Submission for Job: #7056 Remediation, Restoration and Adaptive Re-Use of Campbell's Stores

Site: #3103 Campbell's Stores

My second submission is an objection on HERITAGE grounds in relation to:

3.4.3 Proposed Tenancy Arrangement

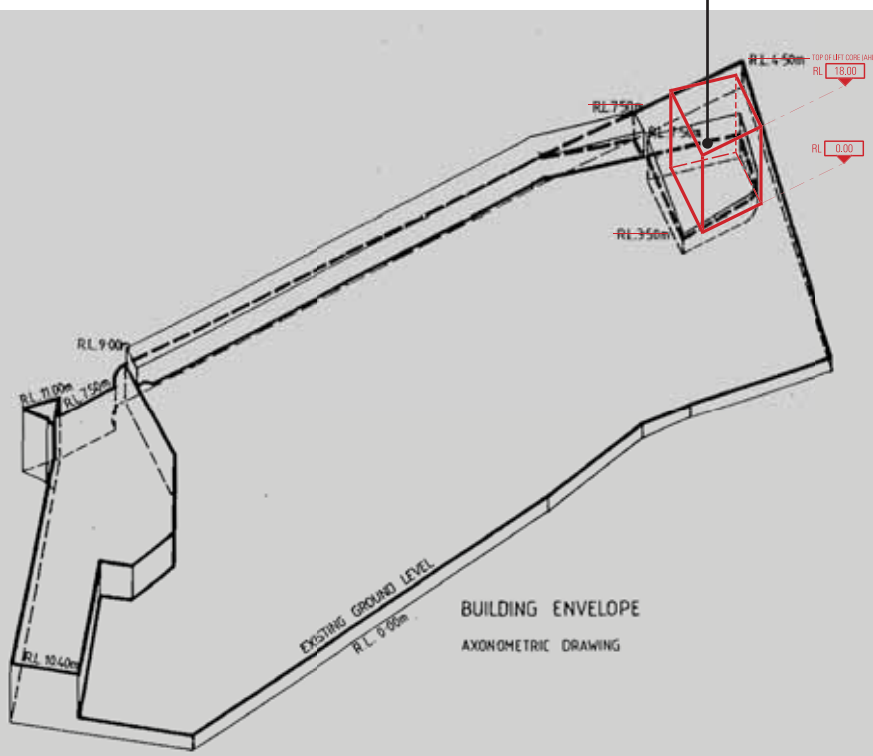
 further incursions into the fabric of the building to facilitate increasing its current 4 tenancies to 'approximately 13' and so further subdivision. This addresses the commercial goals of the applicant at the expense of conserving heritage elements of the building and/or restoring its warehouse configuration. The extent of these is hard to assess as the applicant hasn't provided a subdivision plan or details of the specific usage of the strata lots proposed (reason in itself for this application not to be approved). However, given that the Stores' internal spaces and original internal fabric are ranked as 'Exceptional', the new subdivision of the building will result in further destruction of its original features and materials, further limitation of people's ability to interpret its original warehouse uses and the introduction of materials and features which additionally undermine the Stores' heritage significance.

DIAGRAM: Proposed Voids Locations

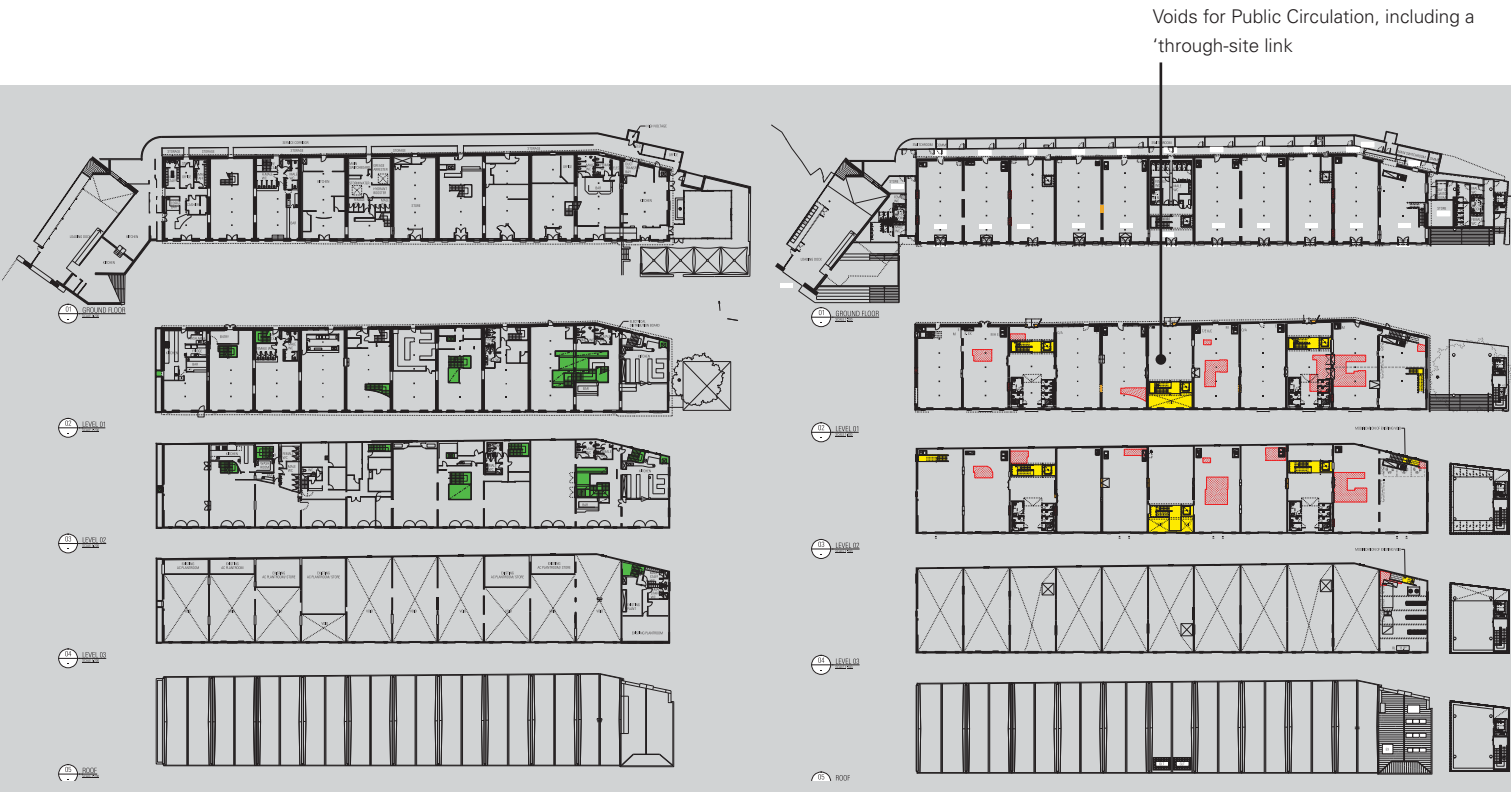
-  the creation of new voids (rather than the re-use of existing voids within the Stores or the re-instatement of the original

voids). This ignores the opportunity to restore, reconstruct and/or interpret the original internal spaces and so does not address the ongoing conservation of the Stores.

 the introduction of a series of new openings in the floors (presumably with the existing voids being closed over). Again, this undermines the Stores' ongoing conservation.

DIAGRAM: Proposed Kitchen Locations

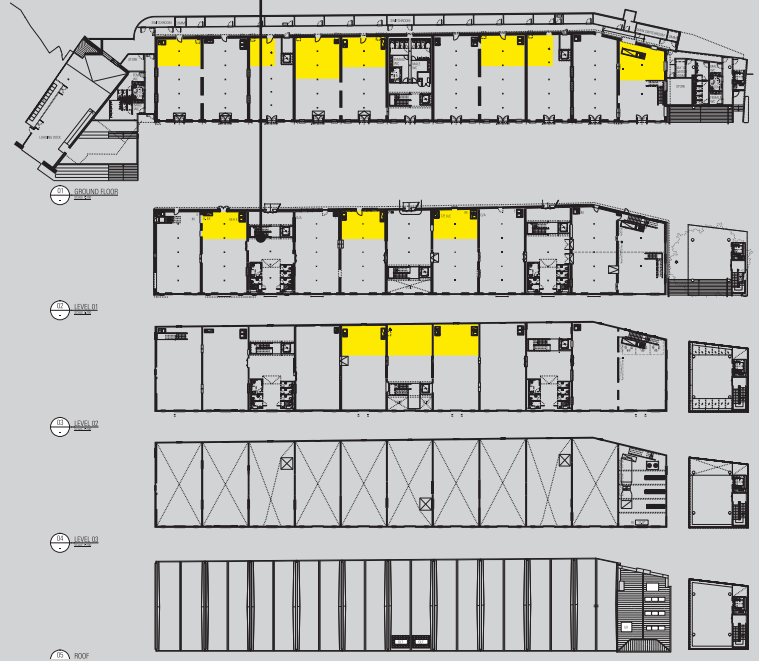
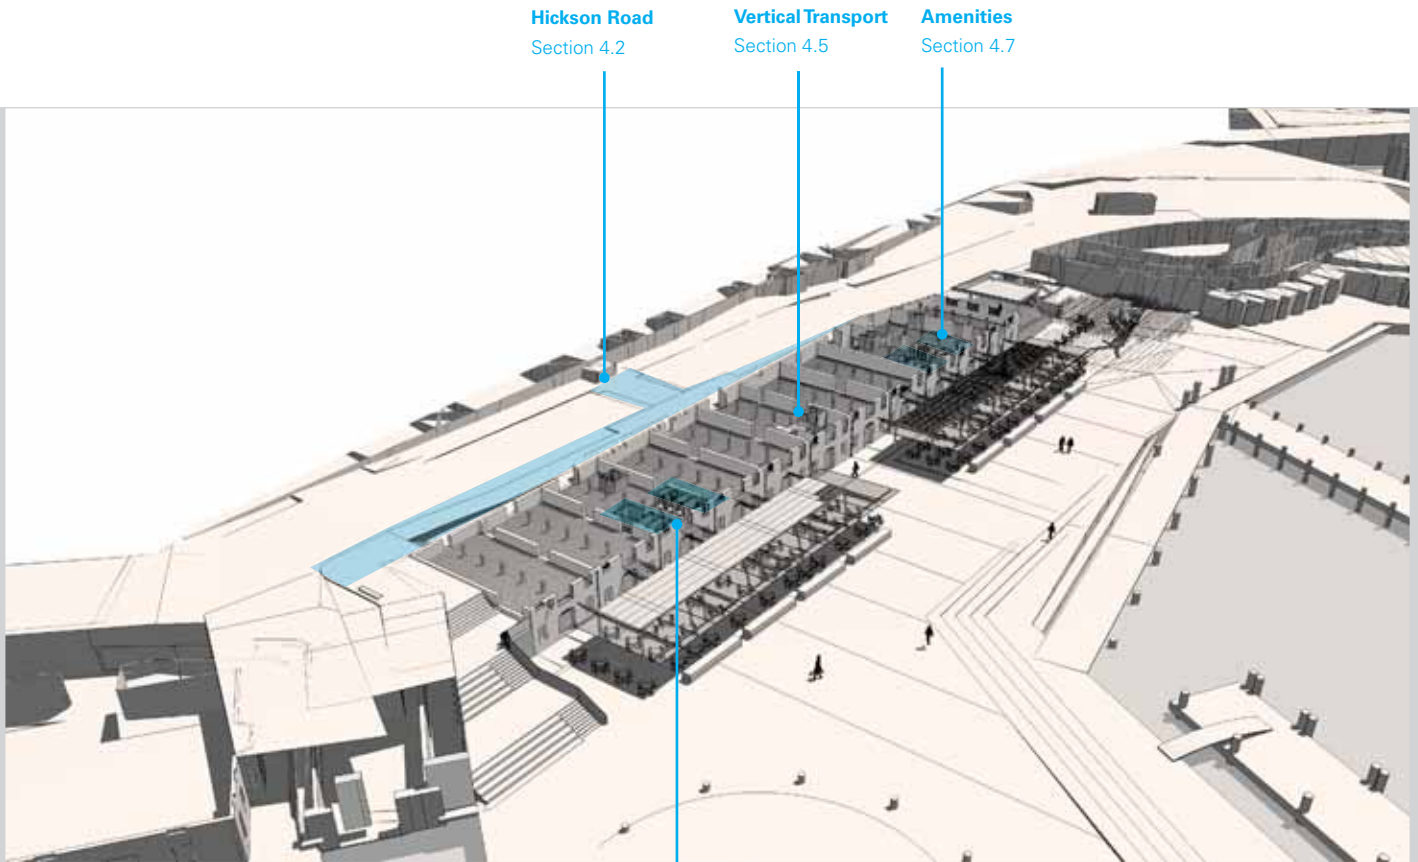
 the consolidation of 9 kitchens currently scattered throughout the building into a grouped arrangement (details not provided). Once again, this suggests significant change to the building's current form with resultant negative implications for its original fabric and further damage to heritage features and significance (see above).

01 WEST ELEVATION
SCALE: 1:200

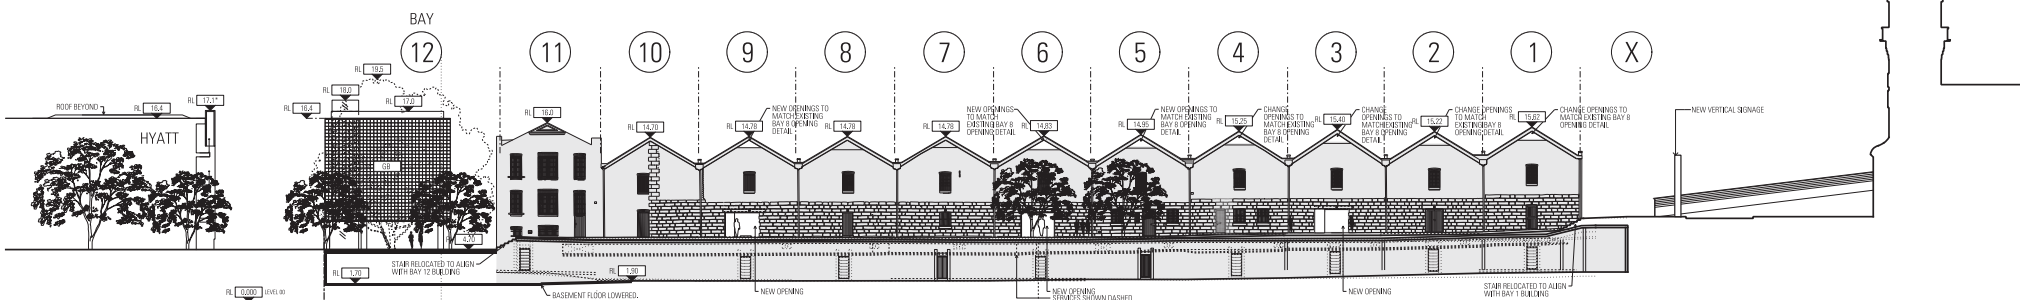
 widening of the existing c.1915 openings on the Hickson Rd frontage to create three new and much larger concrete entry portals. Creating these openings will destroy sections of the building's early sandstone brickwork and the end product will encroach upon the City of Sydney's existing pedestrian footpaths. The openings will all have back-lit signs and the centre opening will cut right through the building further damaging its original fabric.

 the creation of outdoor eating areas, with chairs, tables and umbrellas on Hickson Rd. While this is an appealing image, it would reduce visibility to this (western) side of the Stores and limit people's opportunity to appreciate the building's original form and function. This western elevation is the side that is most in keeping with the original form of Campbell's Stores and the one that most reveals the Stores' 19th century character. To maintain its heritage significance, this façade needs to be kept intact as much as possible.

04 SOUTH ELEVATION
SCALE: 1:200

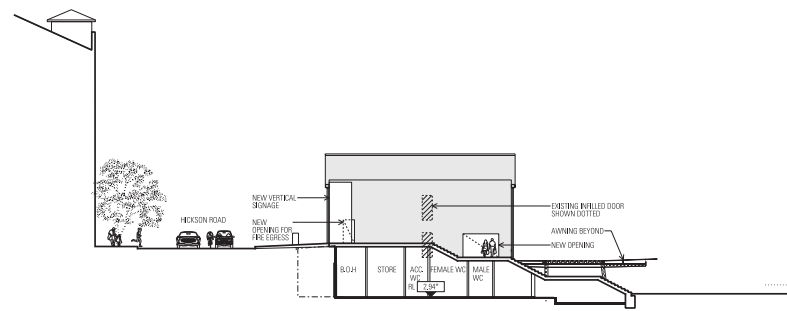
 the creation of two new openings in the south elevation and the closure of one of the heritage openings. This will be a missed opportunity to reveal this elevation in its original form and a further blow to the building's heritage significance.
